Reference: H09-1132-22 **Date of Decision:** 4th April 2023

Location: 35-37 High Street Holbeach Spalding

Description: Change of use of rear ground floor from commercial to self-contained residential unit including internal and external alterations to existing shop

MF/35/37/3

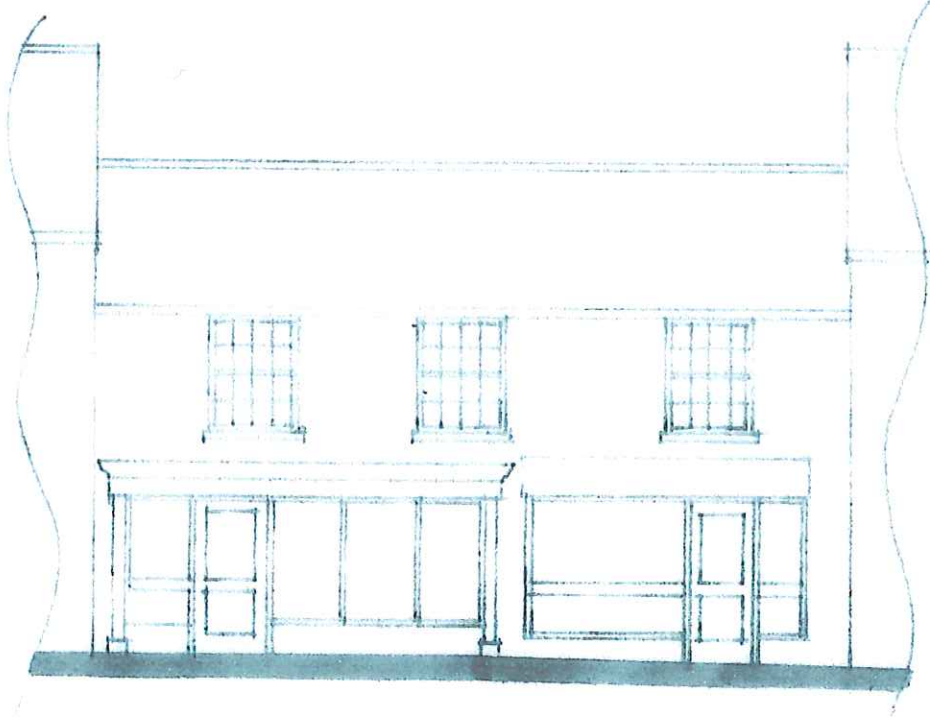
- 3 Prior to installation, large scale details (at a scale of at least 1:20) of the new shop front shall be submitted to and be approved in writing by the Local Planning Authority. The development shall be constructed in accordance with the details so approved.

- 4 The new shop front shall be of timber construction, painted white or cream, and thereafter so maintained.

- 5 All new and replacement external brickwork utilised in carrying out the development hereby permitted, including the stallriser on the front elevation, shall match as closely as possible that of the principal existing building on the site in terms of the type of brick(s), mortar mix and method of bonding.
